REj: Whether a railing a top a shed and a timber fence beside the roof of this feature, the retention of a garden shed comprises exempted development at 3 Wellfeld Close, Monkton Row, Wicklow. - Seamus Mitchell

RE: Application for Certificate of Exemption under Section 5 of the Planning & Development Acts 2000 (as amended) _ Ex 50/18 Seamus Mitchell, 3 Wellfeld Close Wicklow Town.

Ref: EX50/18
Name: Seamus Mitchell
Development: Following the removal of three features comprising: walkway between the house and the roof of the shed) a railing atop the shed and a timber fence beside the roof of the this same feature, the retention of the garden shed which contains 19.1sqm and is located to the rear of Dwelling at 3 Wellfield Close, Monkton Row, Wicklow, comprises exempted development
Location: 3 Wellfield Close Wicklow Town

Fig. 2: The subject structure contains a total floorspace of 19.1 sq. metres

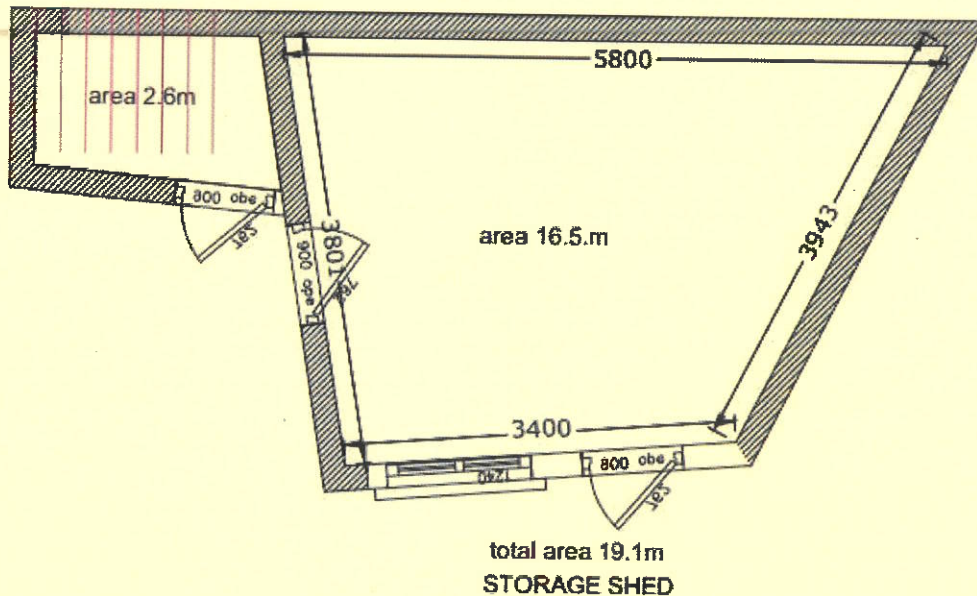
The structure, the subject of this application, currently comprises 2 sheds the roof of which is laid out and designed as an amenity space.

While the applicant has requested that the use of the roof of this structure for sitting out purposes along with the steps which lead from the surface within this site to the roof, be excluded from the referral it is not considered possible to isolate the roof of the shed and its use as an amenity space from the shed as they form part of the same structure. While elements of the existing structure are to be removed it is not considered that these works would be sufficient to ensure that the roof of the structure cannot and would not be used as an amenity space. In particular it is noted that the roof of the site is designed to be easily and directly access via the existing steps.

Fig. 3: The referror proposes to remove the railing and screen which are atop the shed.

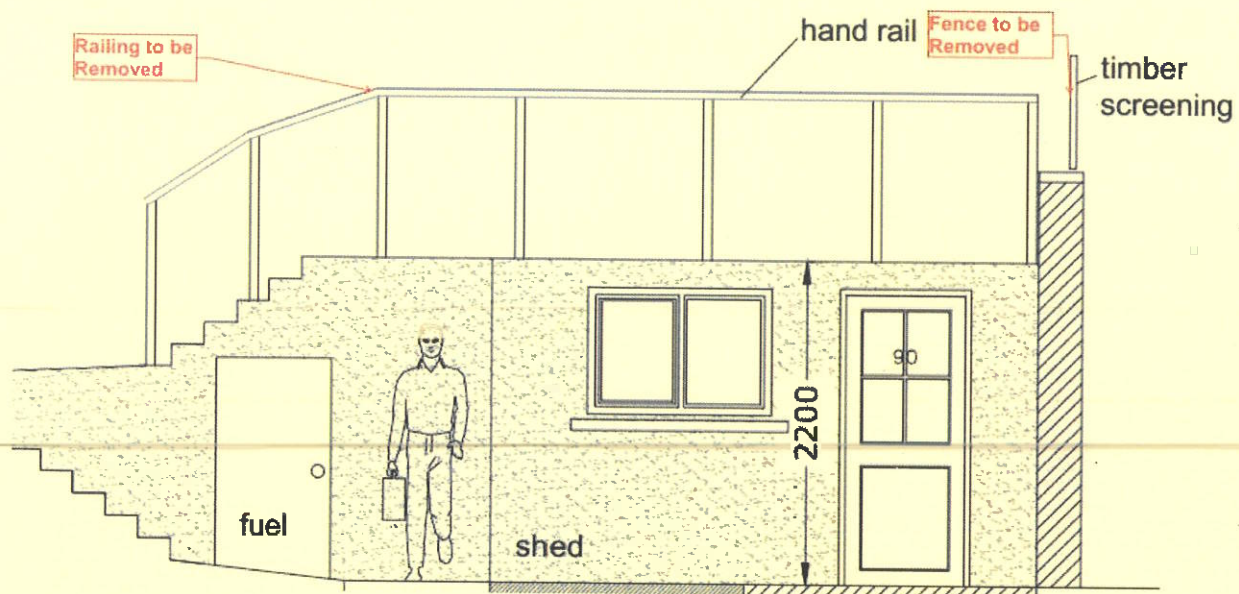
It is noted that the 'removal of the steps which lead from the surface within this site to this roof' does not actually form part of the referral question nor has the removal of the steps been detailed on the submitted drawings, instead it would appear that the applicant wishes the Planning Authority to exclude these steps, along with the use of the roof of the shed for sitting out purposes, from its assessment of this referral question. This however is not considered acceptable or appropriate. The steps form an intrinsic part of the shed structure and therefore they have to be considered as part of this referral as to do otherwise would undermine the referral process and result in a declaration that is without merit.
